EL PASO COUNTY PLANNING AND COMMUNITY DEVELOPMENT DEPARTMENT

GRADING AND EROSION CONTROL PLAN CHECKLIST

SHEET 1 OF 9  
JOB NO. 25176.00

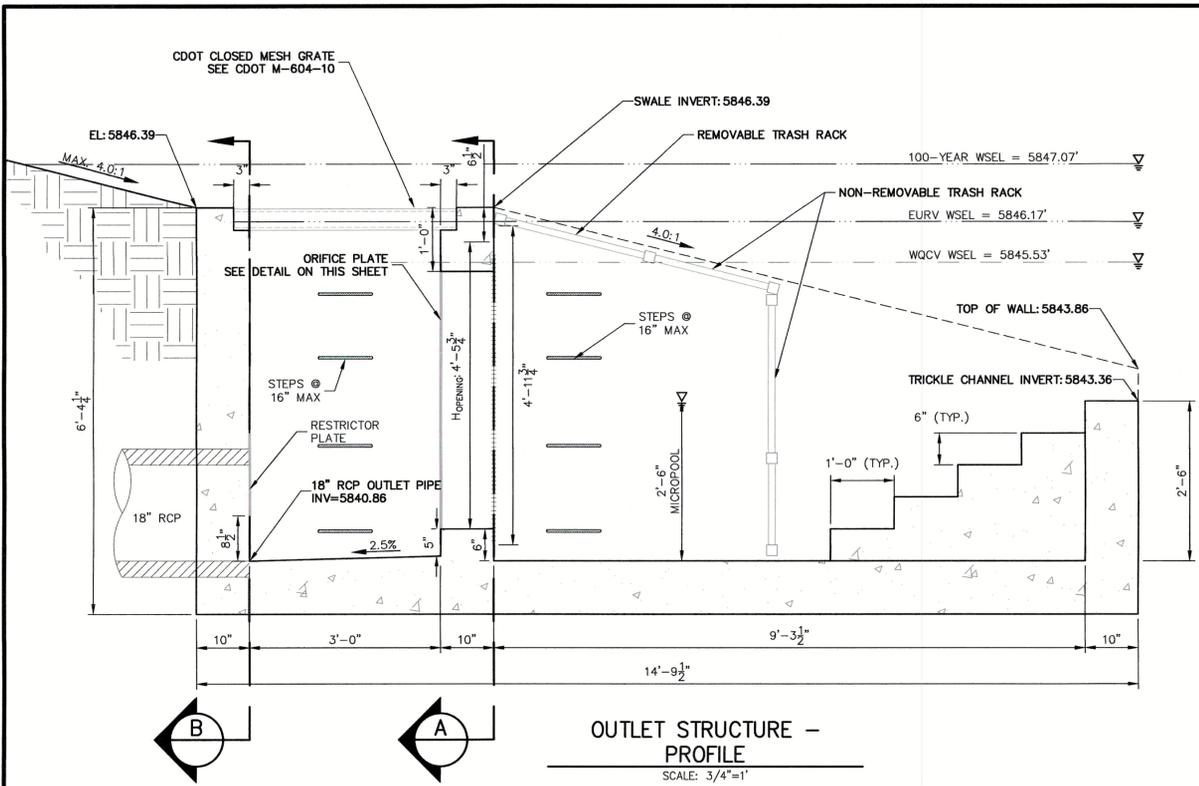
| | | Applicant | PCD |
|----|---|-----------|-----|
| hh | <p>Owner's Statement (for standalone GEC Plan): I, the owner/developer have read and will comply with the requirements of the Grading and Erosion Control Plan.</p> <p>_____ Owner Signature Date</p> <p>See comments on Sheet 1</p> | Y | X |

SHEET	4	OF	9
-------	---	----	---

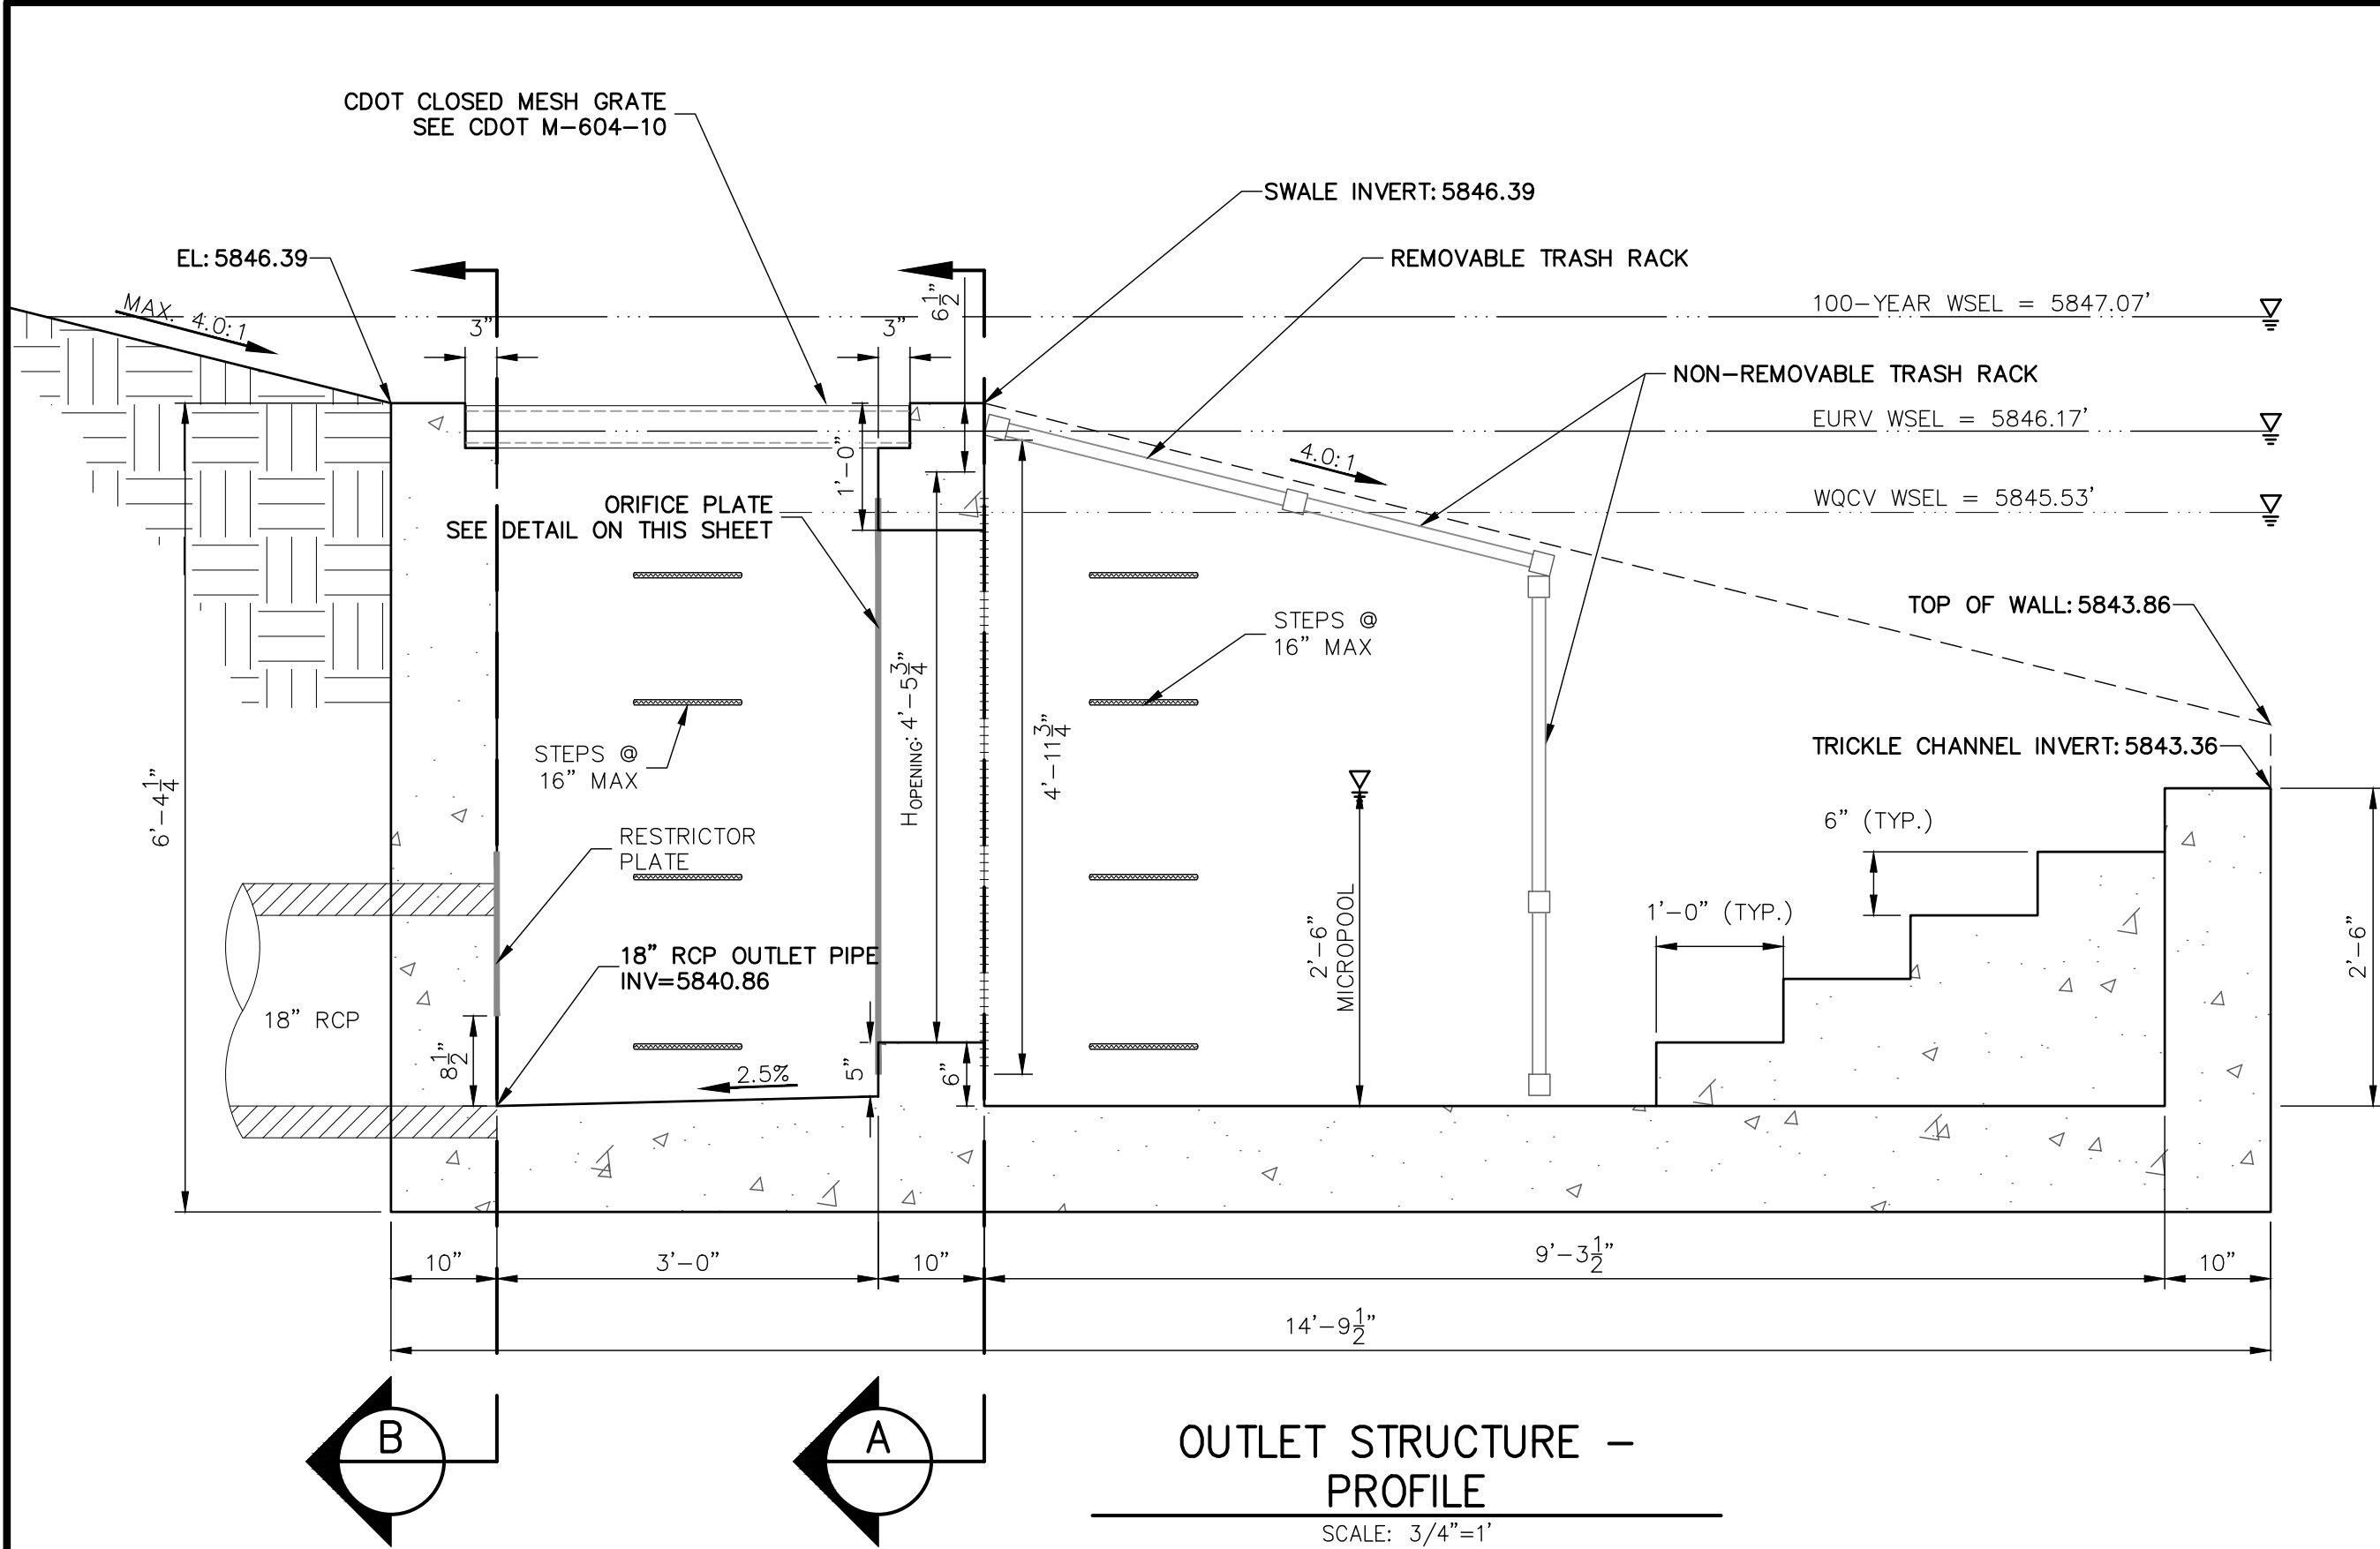
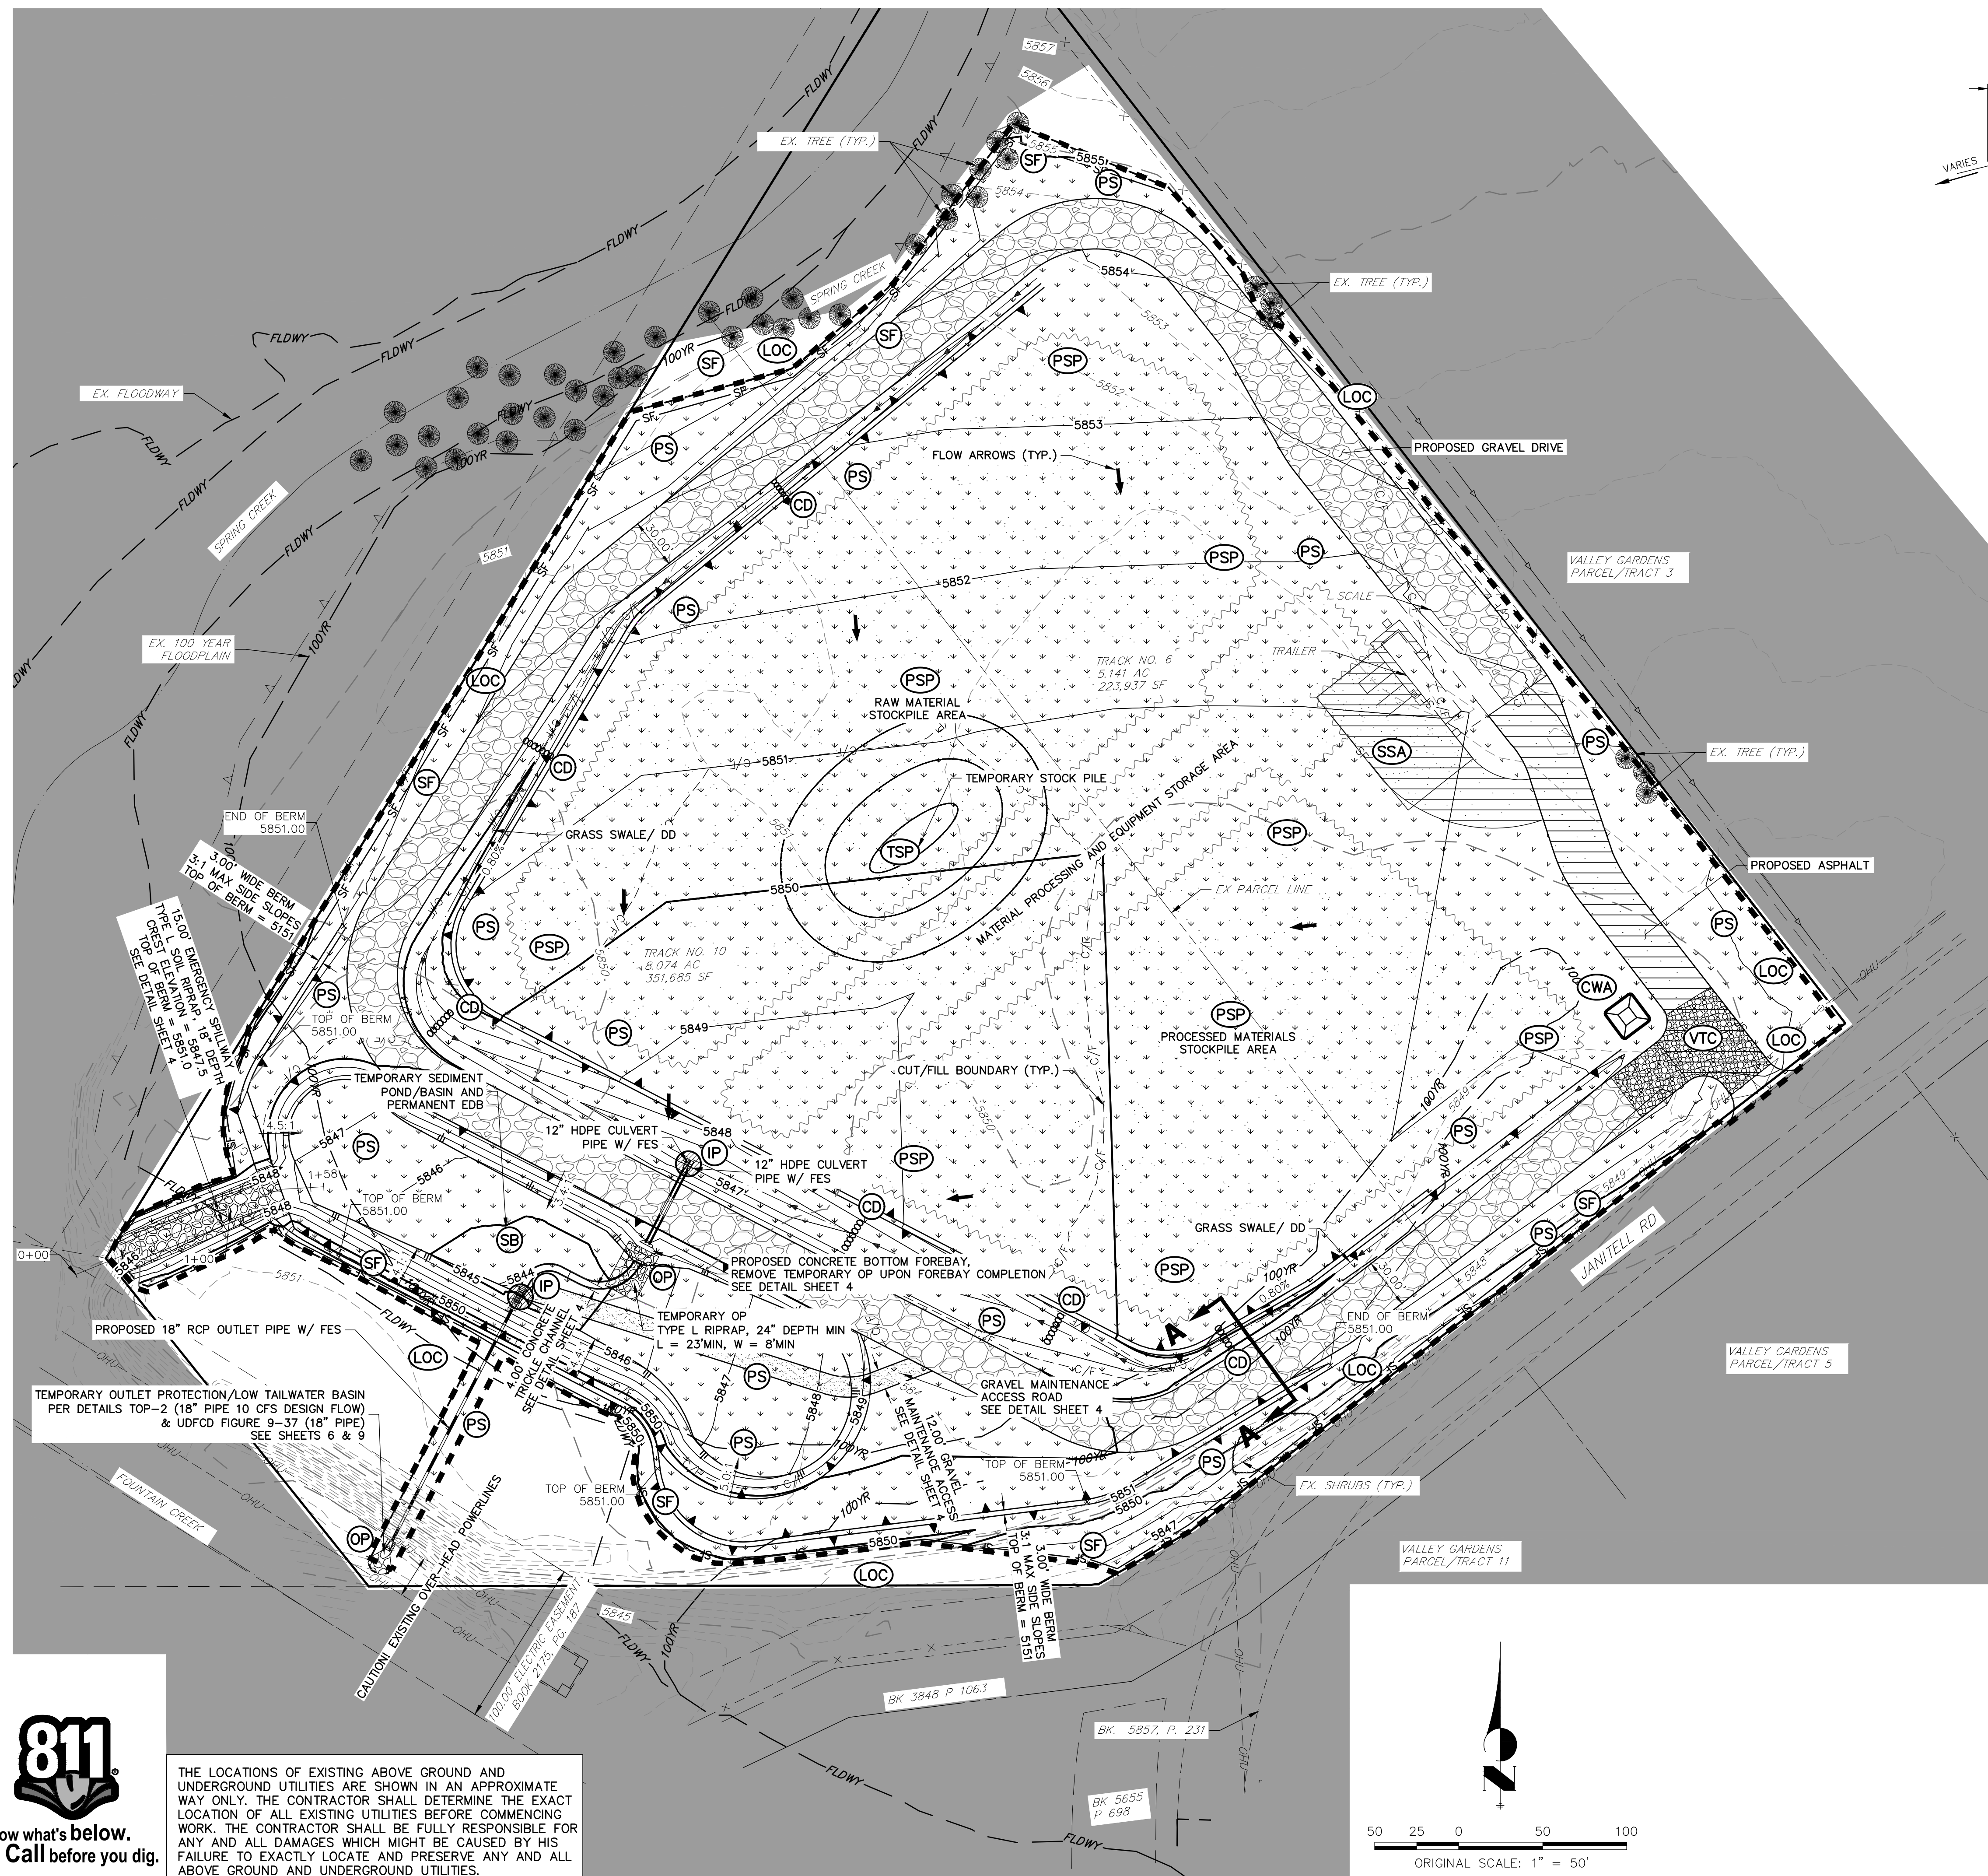
| | | Applicant | PCD |
|--|---|-----------|-----|
| z | All proposed temporary construction control measure details. Custom or other jurisdiction's details used must meet or exceed EPC standards. | Y | X |

See comments on Sheets 4 & 7
